**Springdale Solar Farm (SSD 8703)  
EIS Exhibition**

Alison Collaros  
A/Manager, Assessment Advice  
**Lands and Water - Strategy and Policy**  
14 August 2018

**Springdale Solar Farm (SSD 8703)  
EIS Exhibition**

Figure 5 Surface water and drainage lines

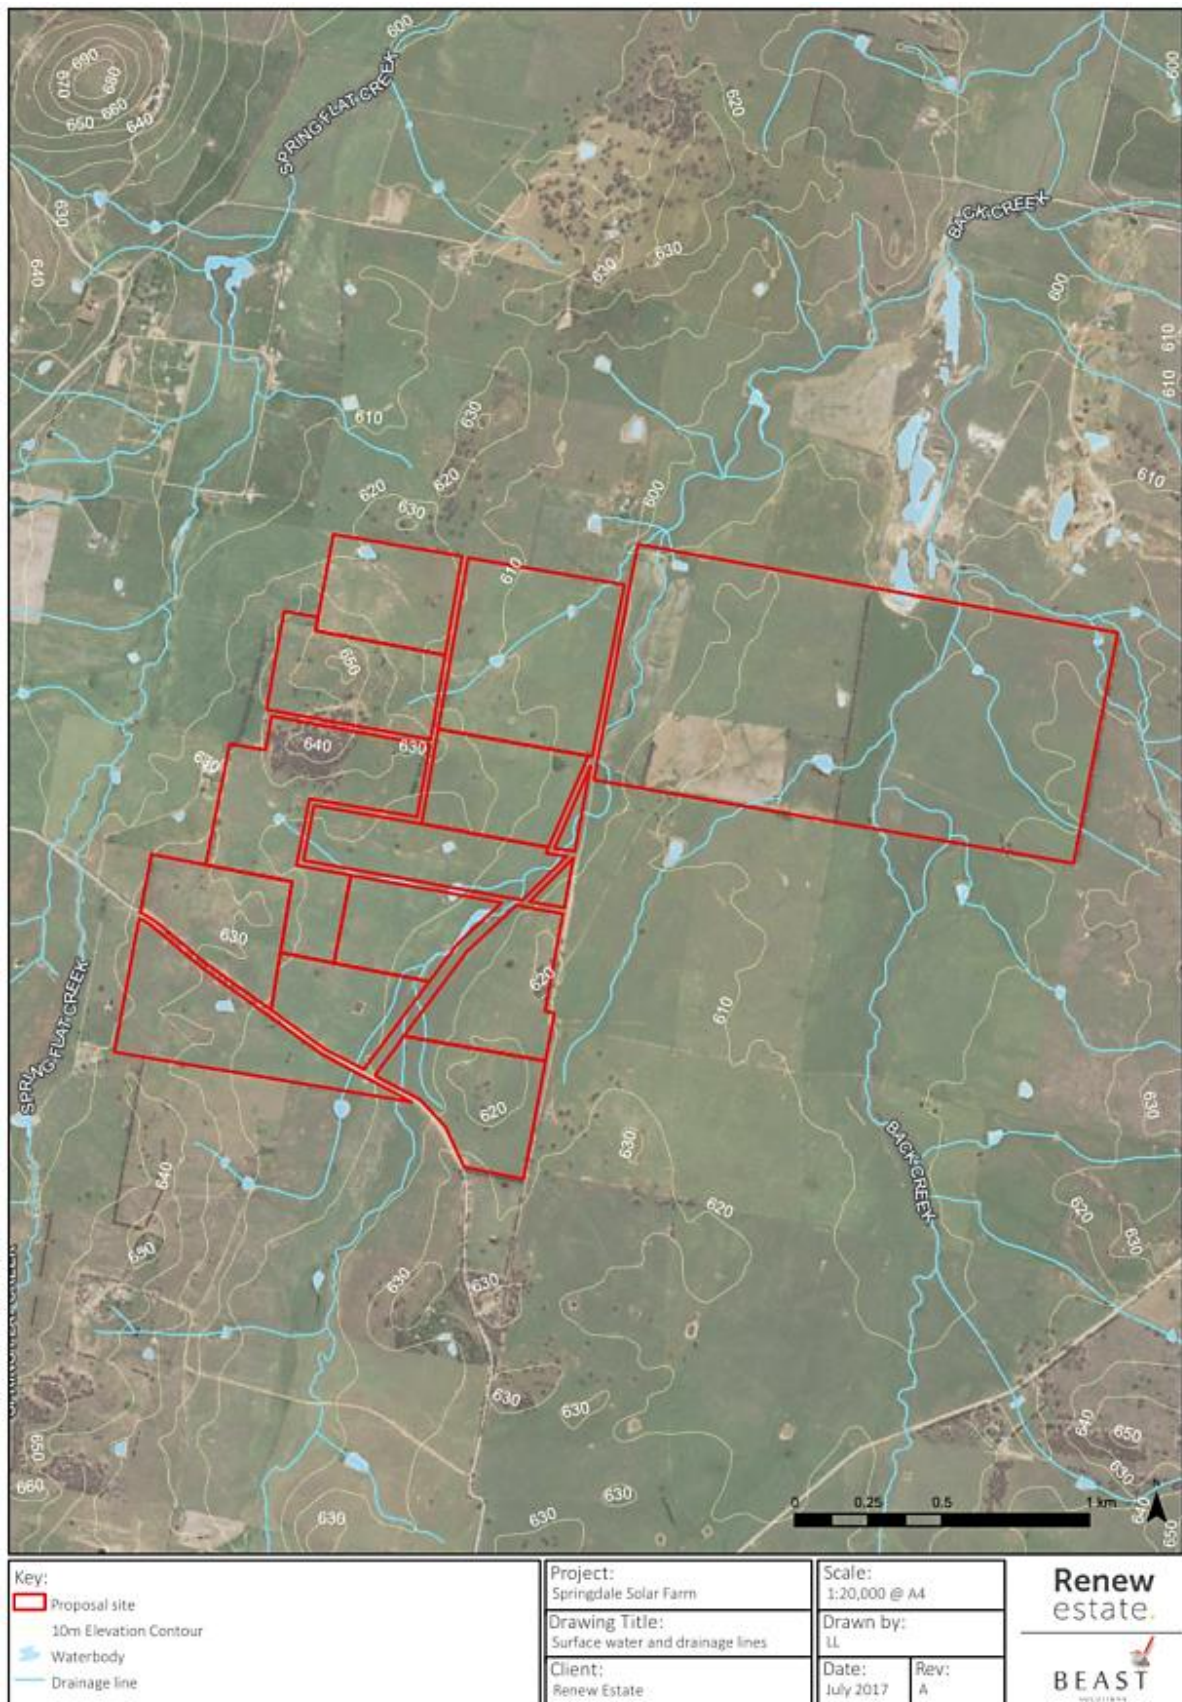
- Lands and Water databases indicate Back Creek and the central Tributary on the project site are 4th order and 3rd order watercourses respectively. Table 25 on p 105 of the EIS Report and Figure 22 should be corrected to reflect this and the relevant vegetated buffers be applied.

- A number of first order watercourses are located within the solar panel array footprint. The riparian value of these is recognised to be limited, however it is recognised based on the flood modelling that flows will be conveyed via these watercourses. Management of vegetated buffers and of these flow lines should focus on retaining adequate vegetation cover to mitigate erosion.
